CDR21013-R1-CDs.pdf Markup Summary

C101

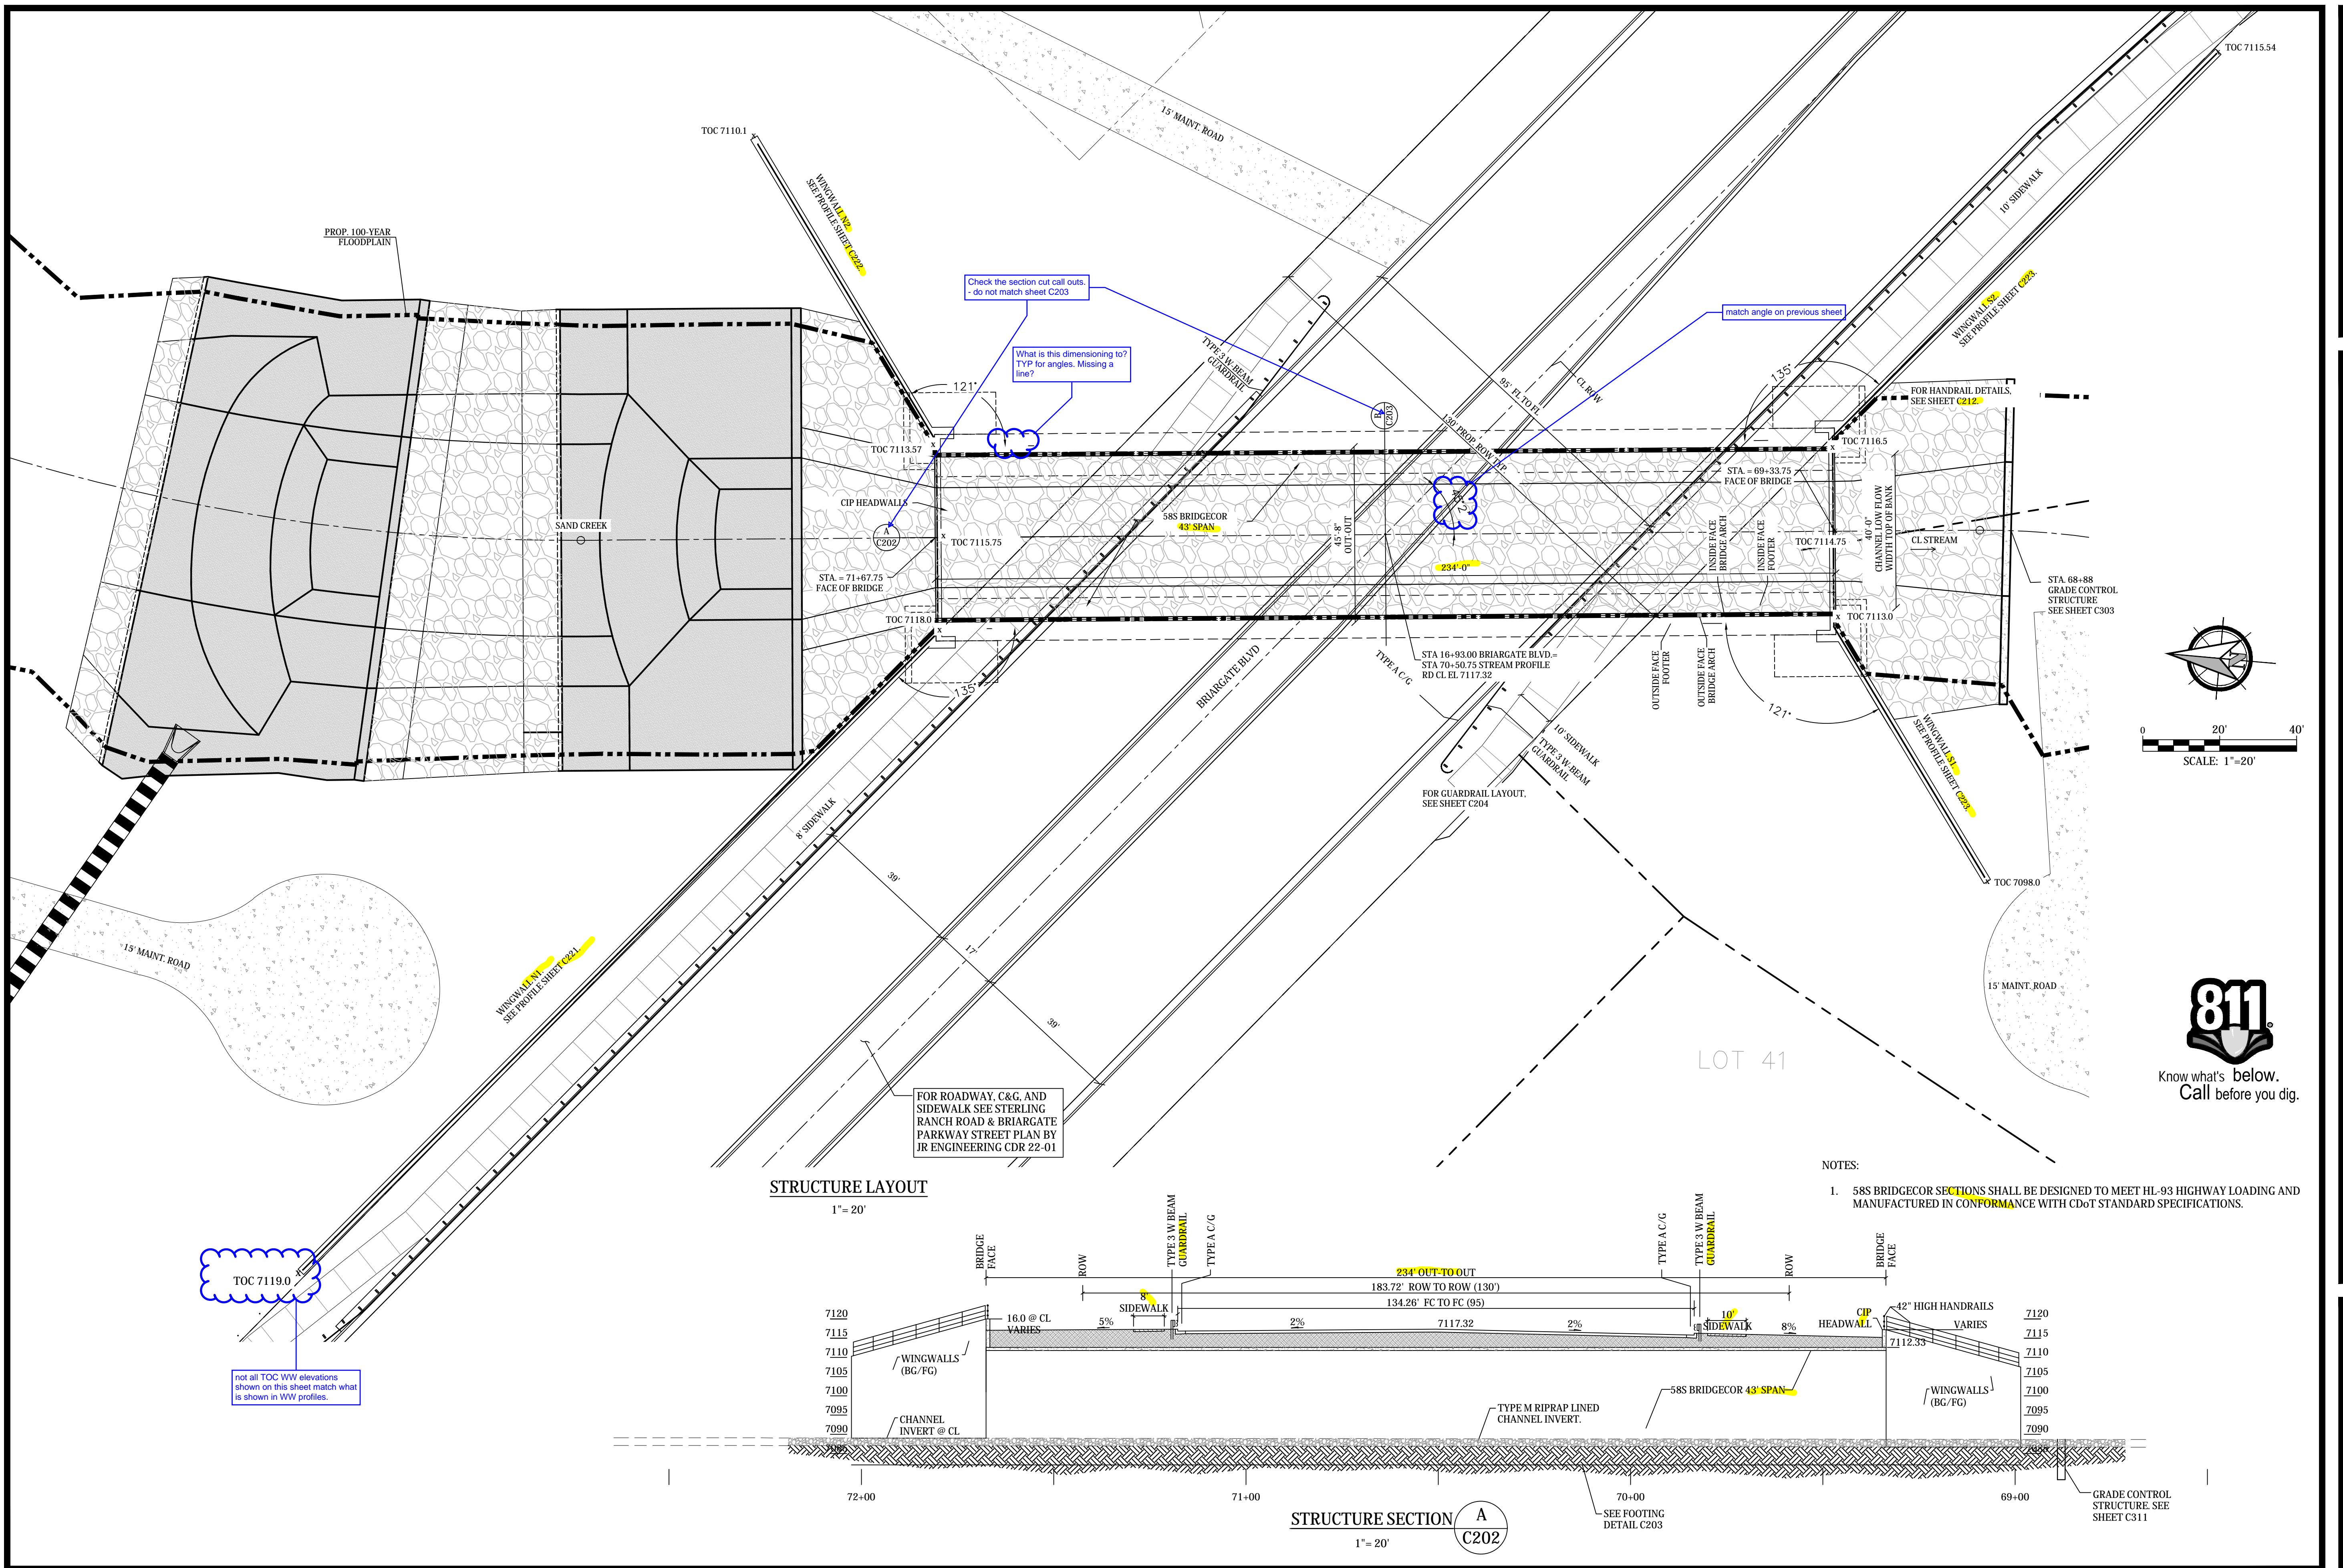
Detail will be needed for this area

label 4:1 slope

label maint. access

Show and label lots and tracts including parcels that will be transferred to the County for bridge ownership.

STERLING RANCH DEVELOPMENT
BRIARGATE BOULEVARD BRIDGE CONSTRUCTION PLANS
GRADE CONTROL STRUCTURE DETAILS
EL PASO COUNTY, COLORADO

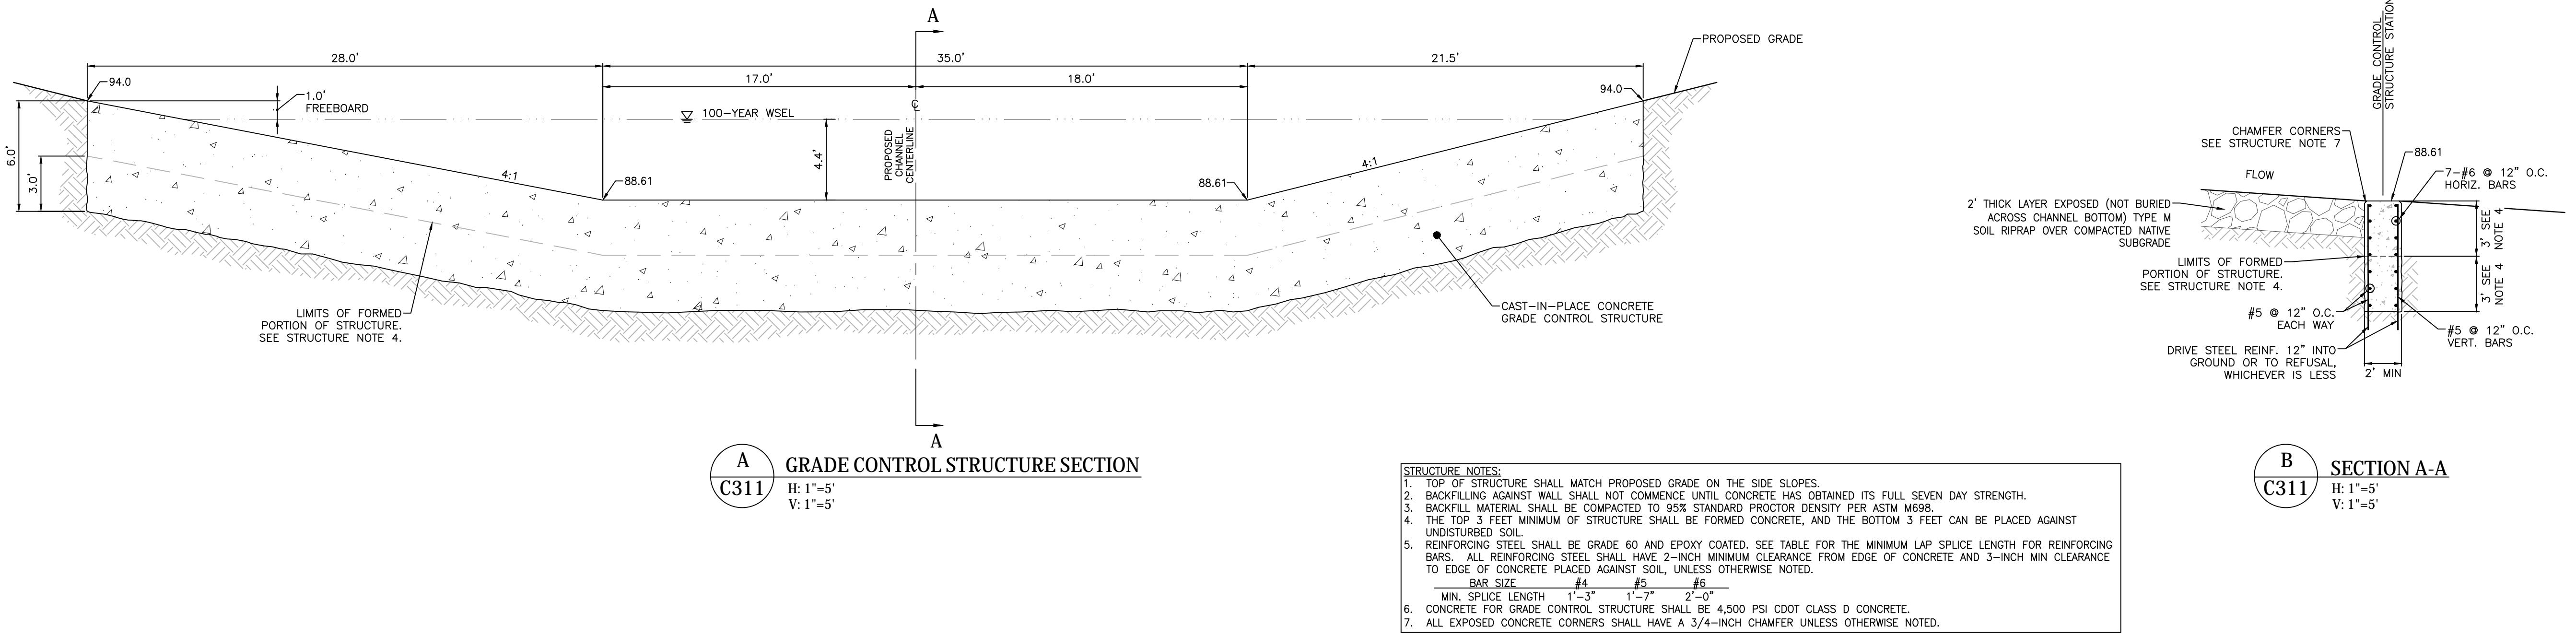
label grade control sheet pile

**STERLING RANCH DEVELOPMENT
BRIARGATE BOULEVARD BRIDGE CONSTRUCTION DRAWINGS
STRUCTURE LAYOUT**
EL PASO COUNTY, COLORADO

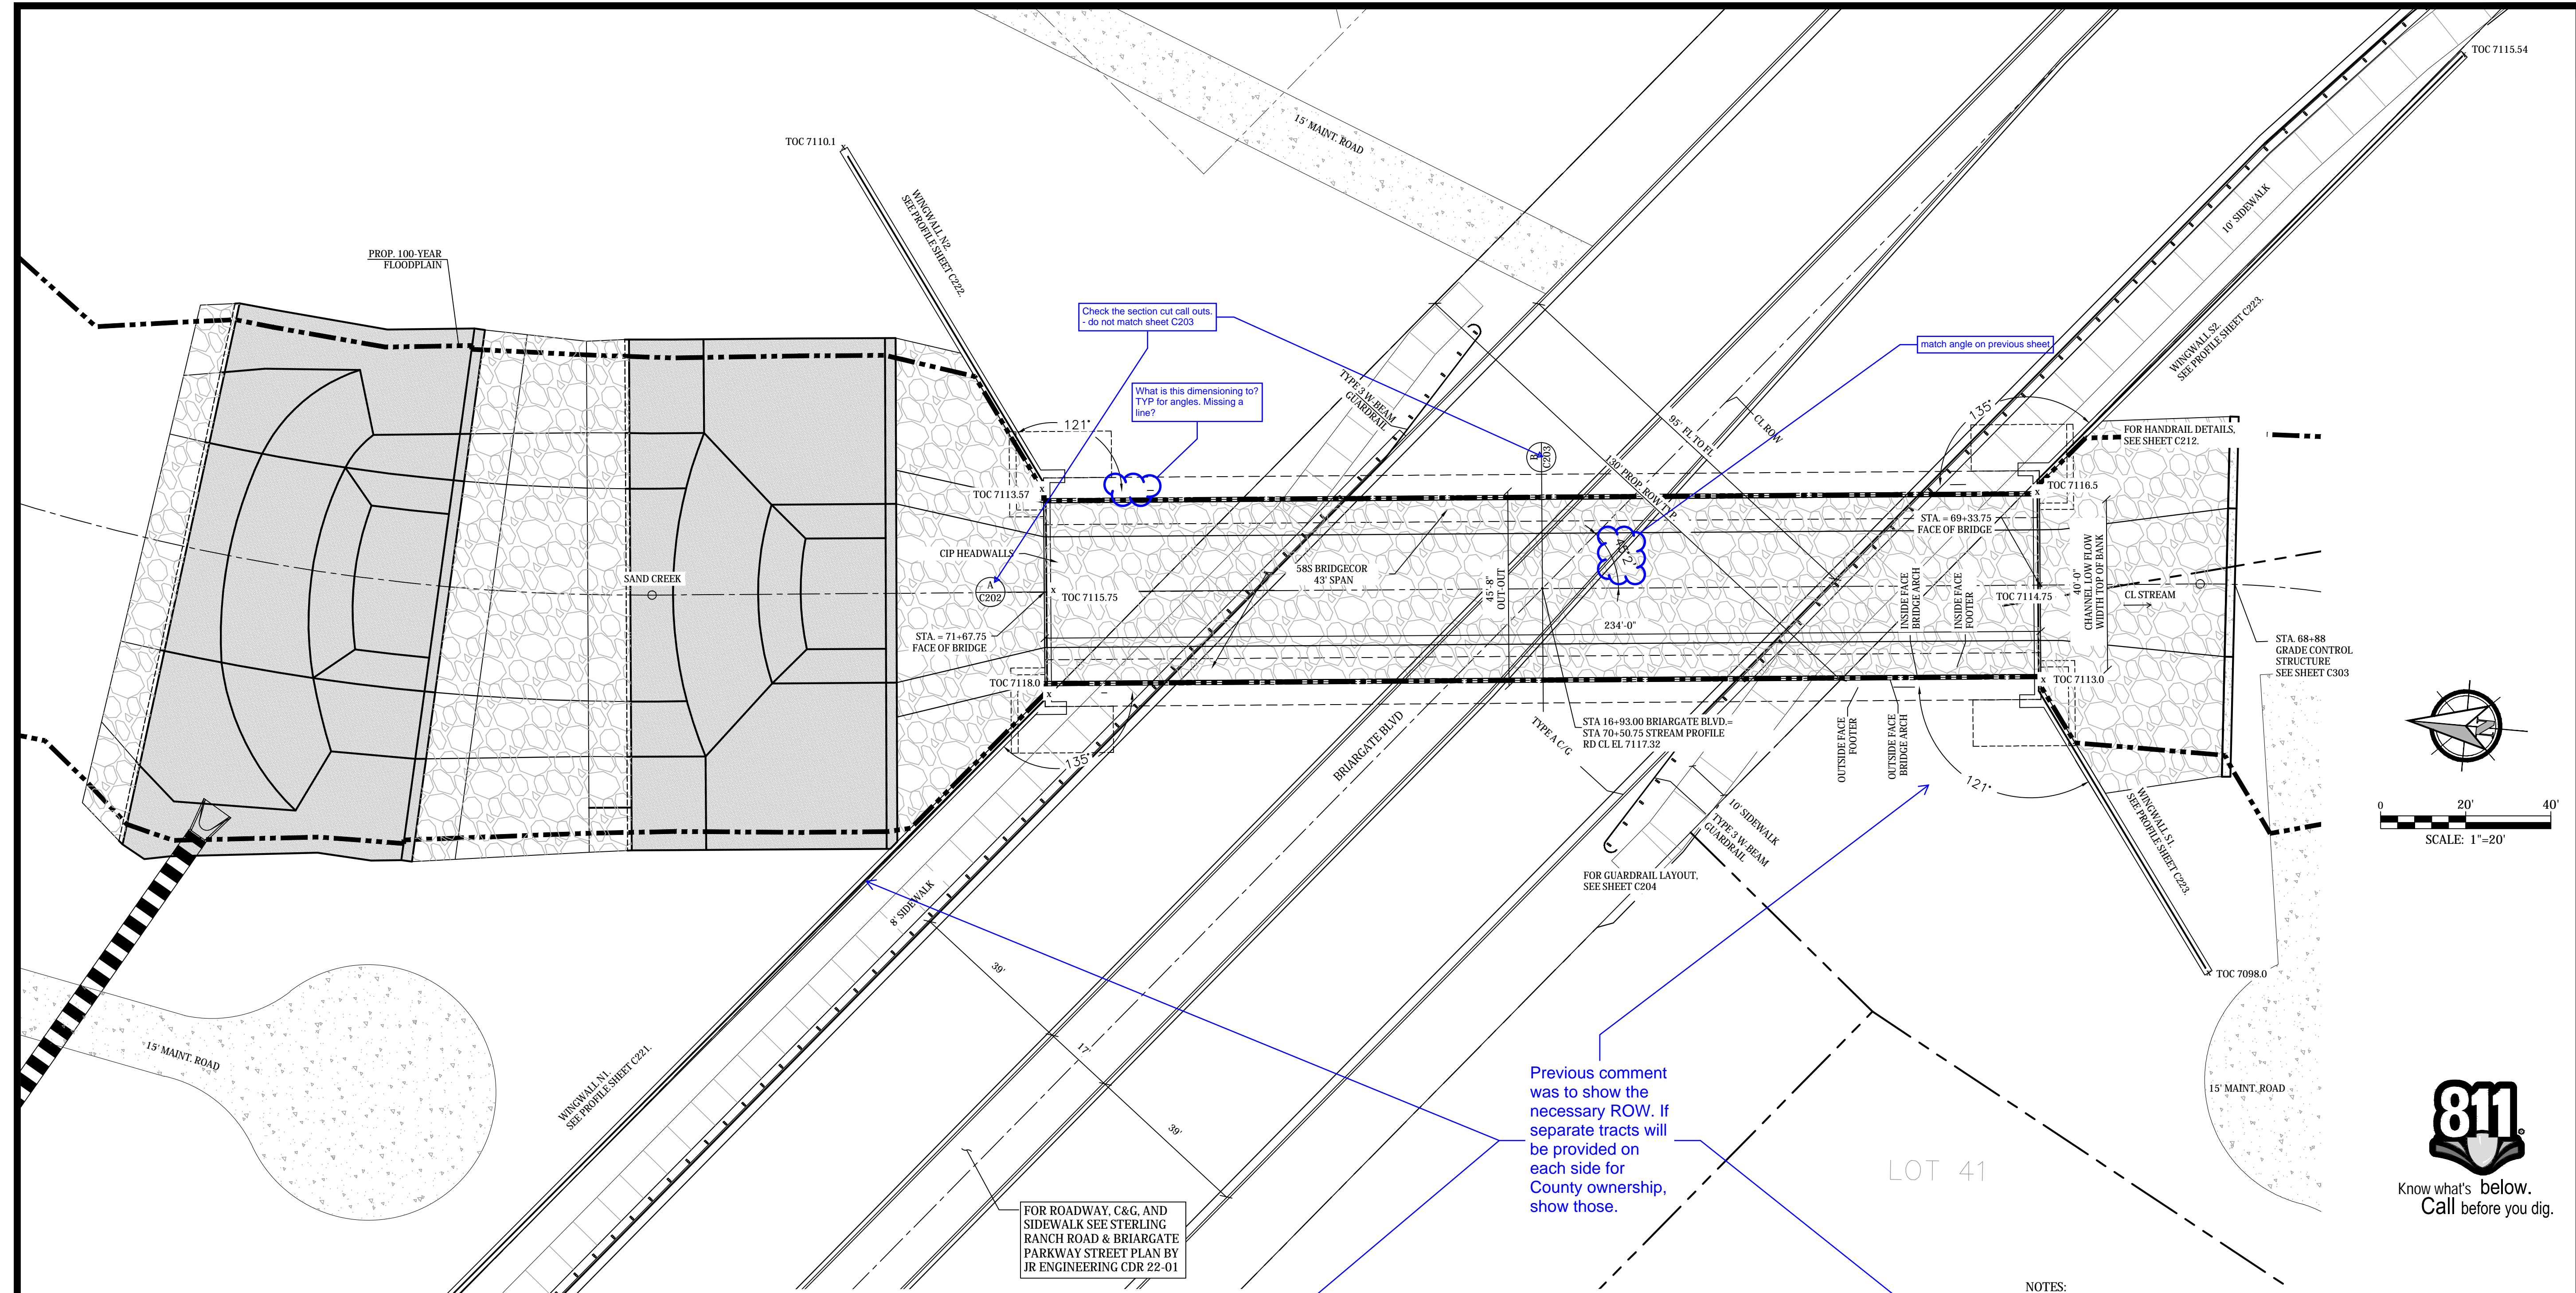
Provide a profile of the sheet pile.
